Rezoning Transportation Analysis

Petition Number: Insert Zoning Petition #2021-277

General Location Identifier: 15501125, 15501126

Revision Log:	Date	Description
	05-18-2022	First Review (WB)

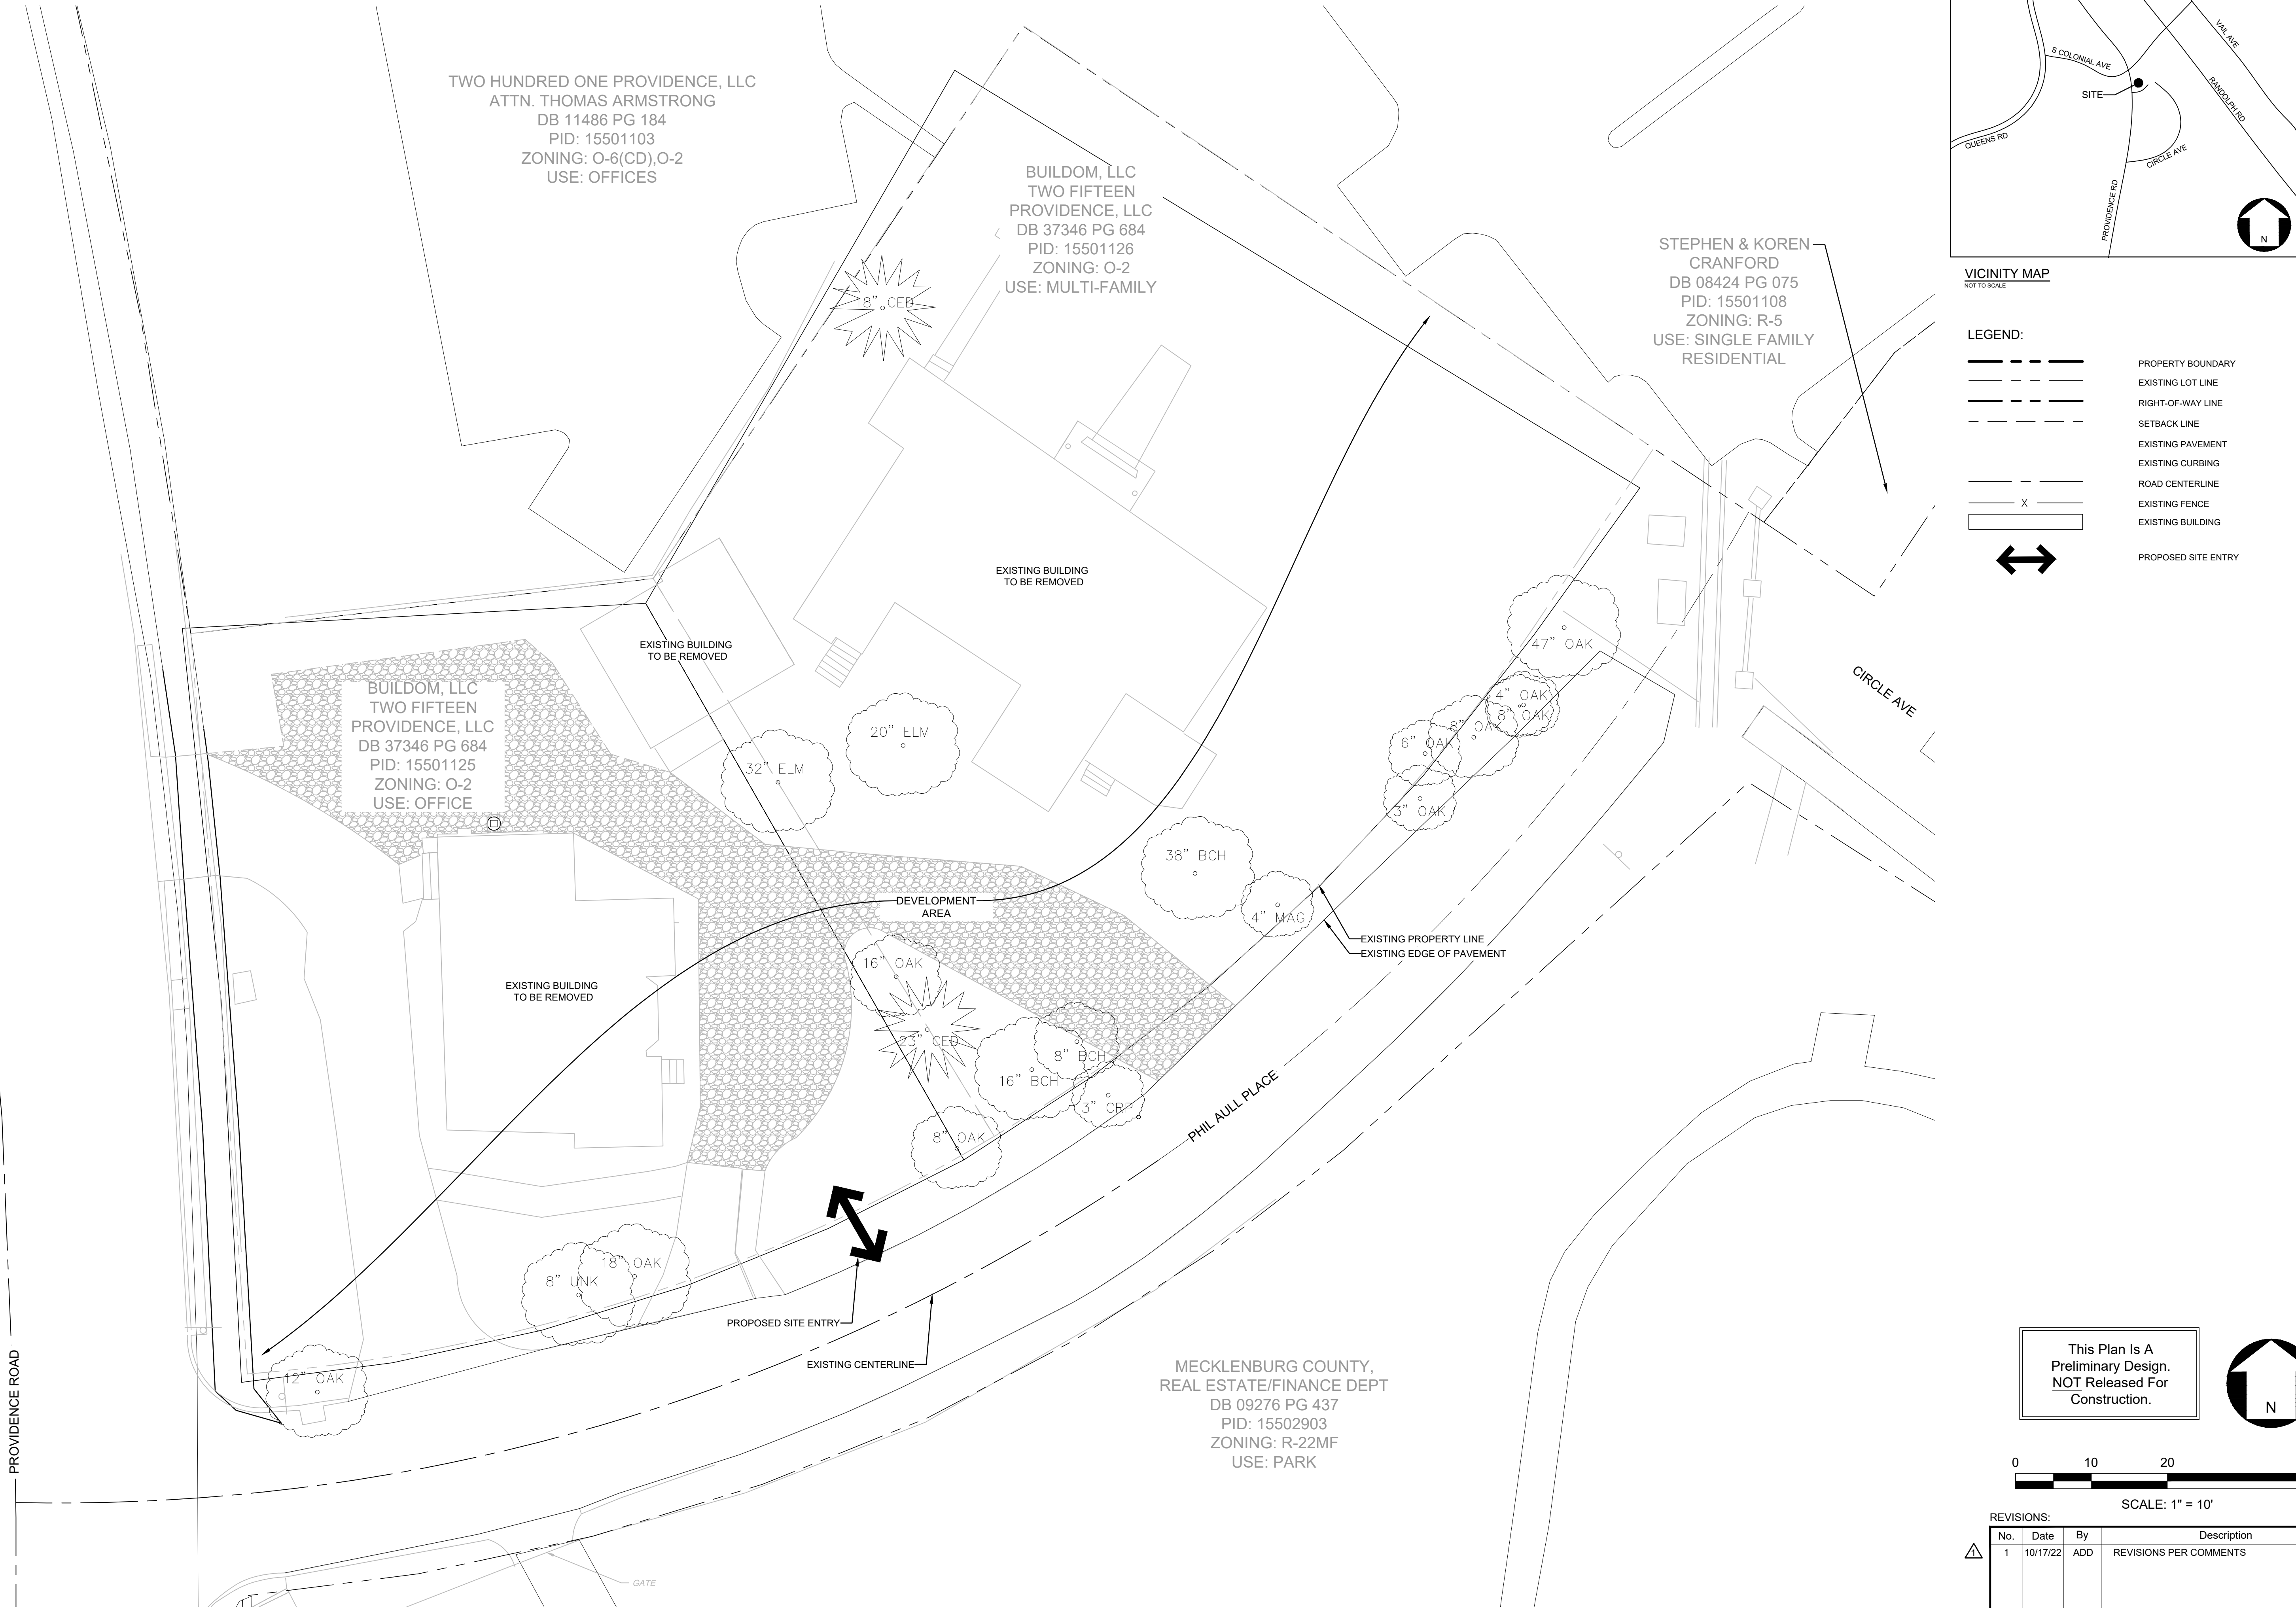
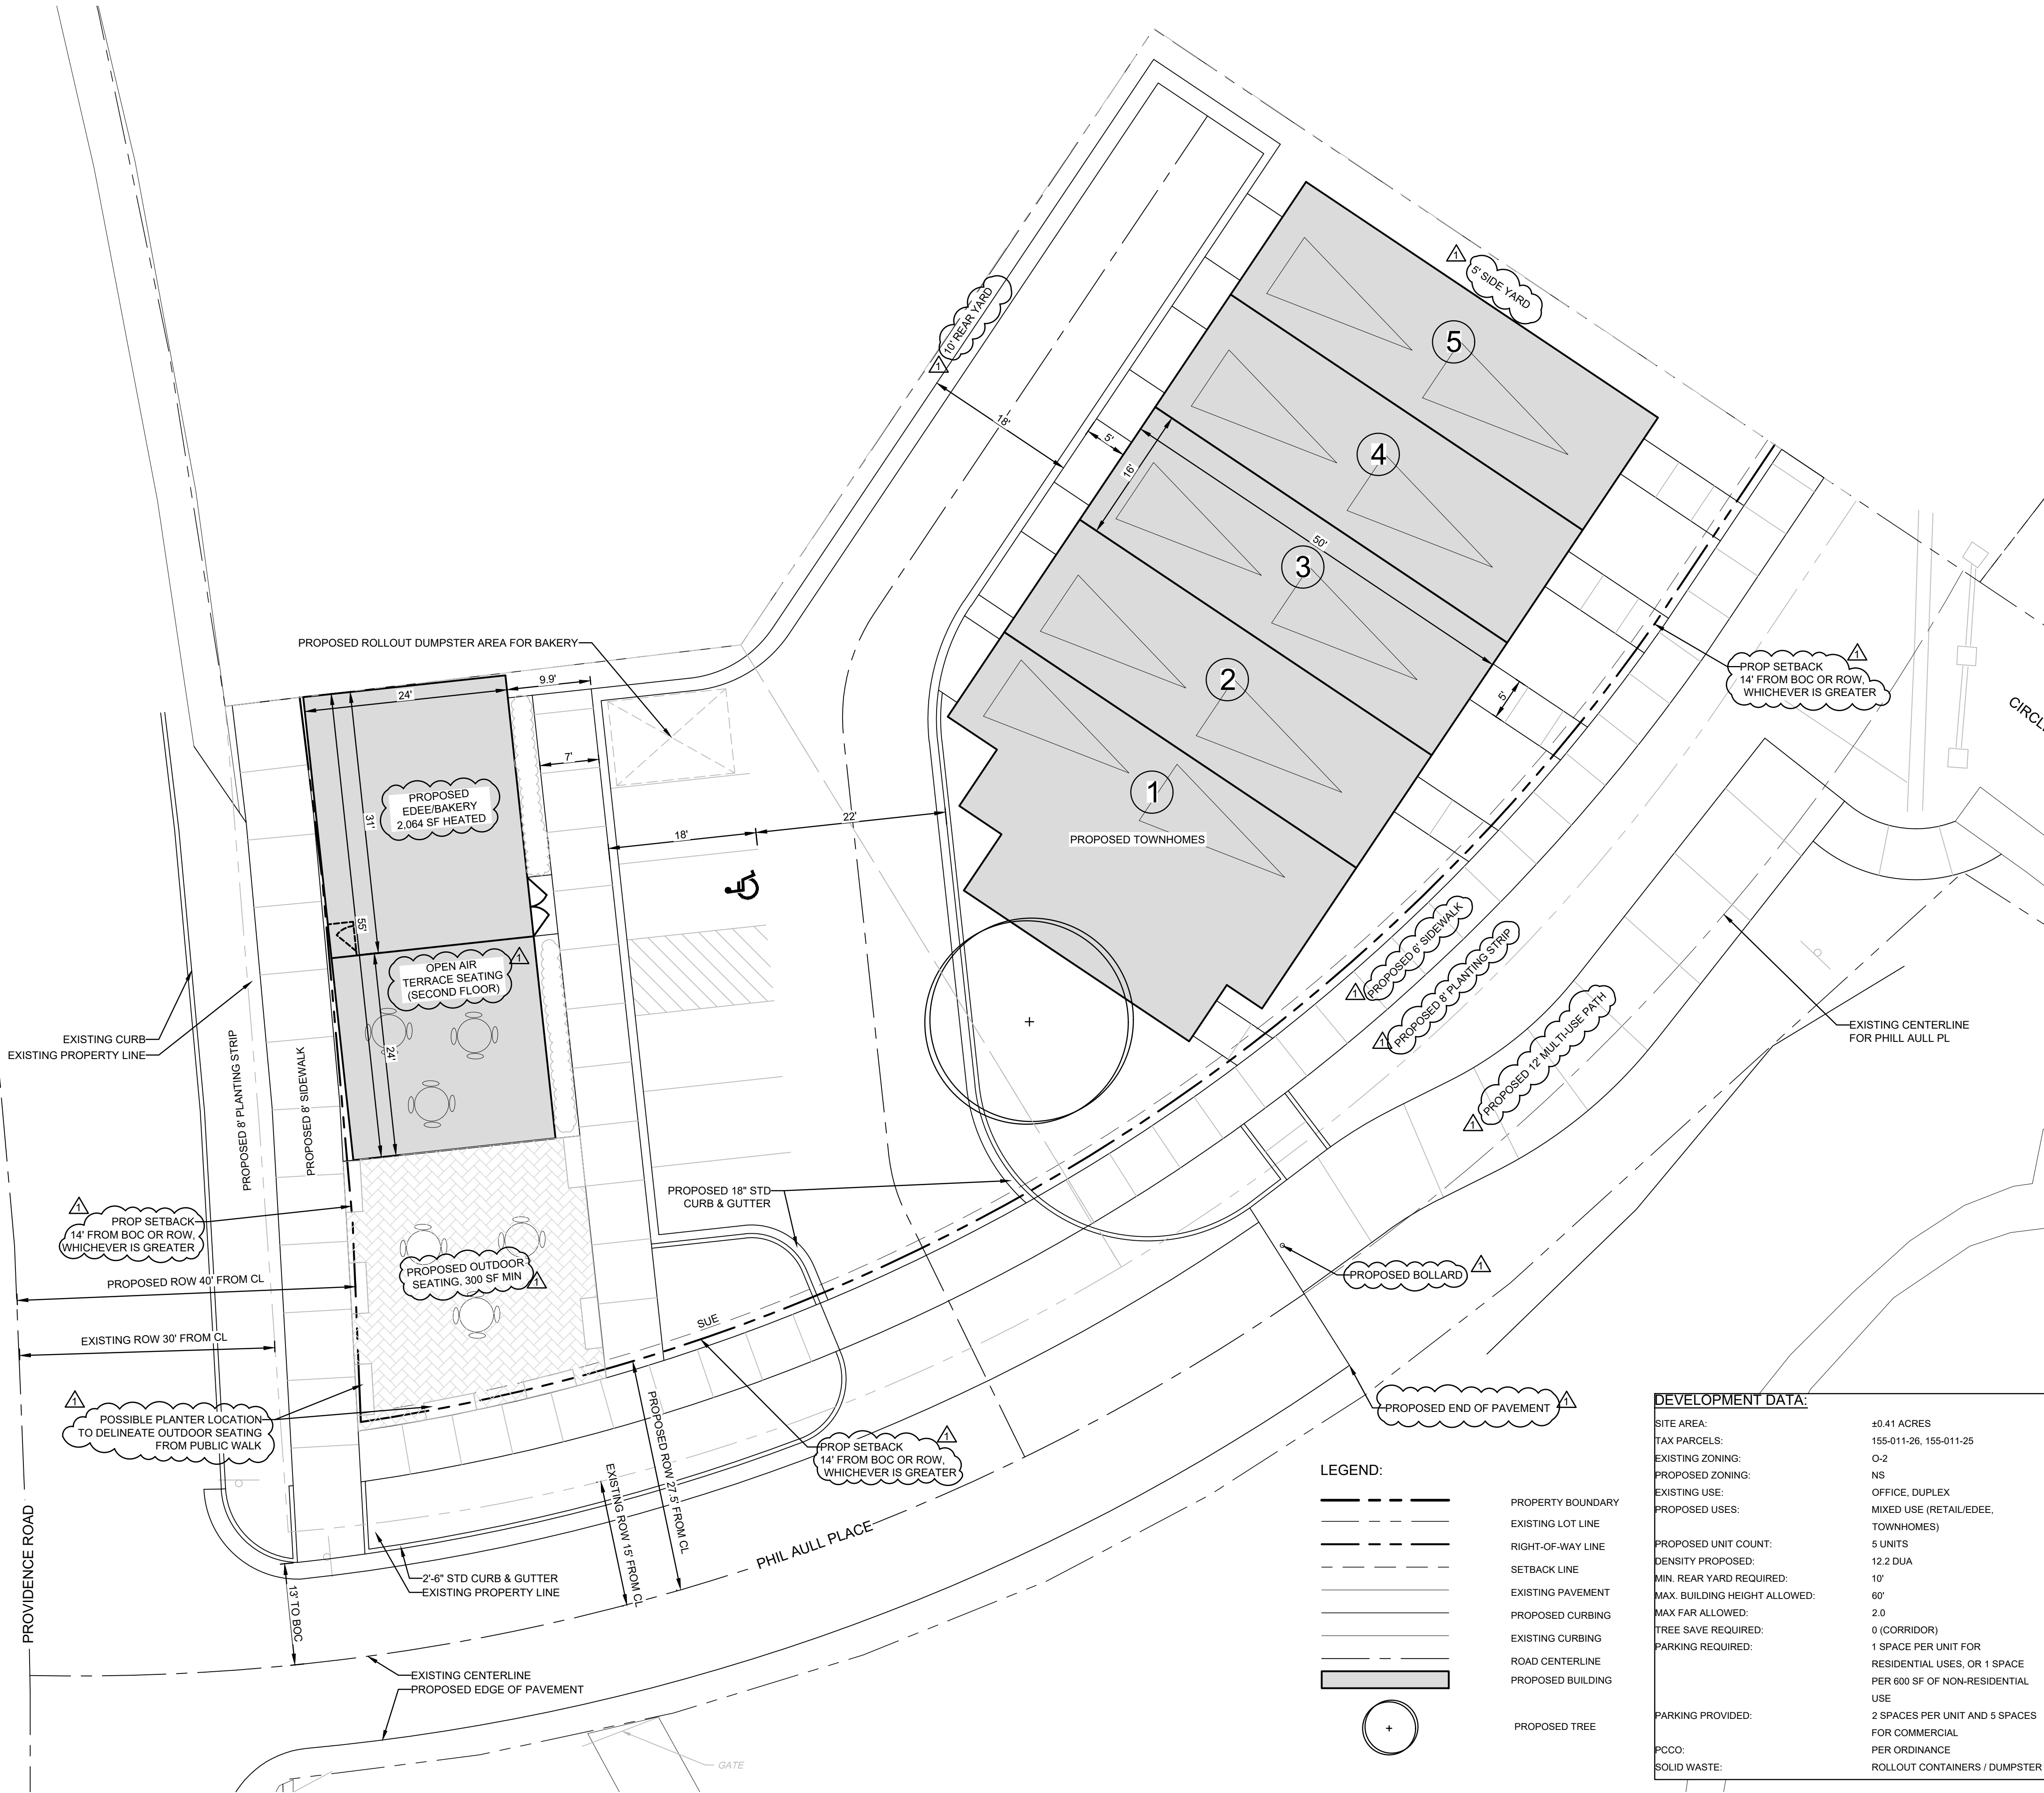
1. **Curblin**~~e~~: The proposed zoning district has a setback measured from back of the existing or proposed future curblin~~e~~.
 - a. **Providence Road**: The future curb and gutter shall be located 32.5-ft from the centerline. This offset represents the future typical section of a 4+ Avenue with Buffered/Separated Bike Lanes. No relocation of the Curb & Gutter is required with this project; however, plans must label and dimension the future location.
 - a. **Phill Aull Place**: The future curb and gutter shall be located 20.5-ft from the centerline. This offset represents a Local Commercial Wide Typical section with on-street parking along the site's frontage.

Label and dimension the curb and gutter from the centerline for each road on the site plan.
2. **Traffic Study**:
A Traffic Impact Study (TIS) is not necessary for the complete review of this petition due to the site generating less than 2,500 daily trips. If during the permitting process the site generates more than 2,500 daily trips, then a traffic study will be required.

3. Revise site plan and conditional notes to commit to dedicate 40-ft (min) right-of-way from the Providence Road centerline. Provide a sidewalk utility easement (SUE) 2-ft behind the future back of sidewalk (50.5-ft from the centerline). The site plan shall label and dimension the right-of-way from the road centerline.

4. Revise site plan and conditional notes to commit to dedicate 28.5-ft (min) right-of-way from the Phill Aull Place centerline per CLDSM U-05A. The site plan shall label and dimension the right-of-way from the road centerline.

5. Revise site plan and conditional notes to commit to construct an 8-foot planting strip, and 8-foot sidewalk on Phill Aull Place per Chapter 19 and CLDSM U-05A. The site plan shall label and dimension both items from the back of curb and gutter and road centerline.

- Site plan and conditional notes revisions are needed to provide an ADA compliant pedestrian connection from Phill Aull Place to Circle Avenue.

- Adequately depict the existing Circle Avenue right-of-way at Phill Aull Place.
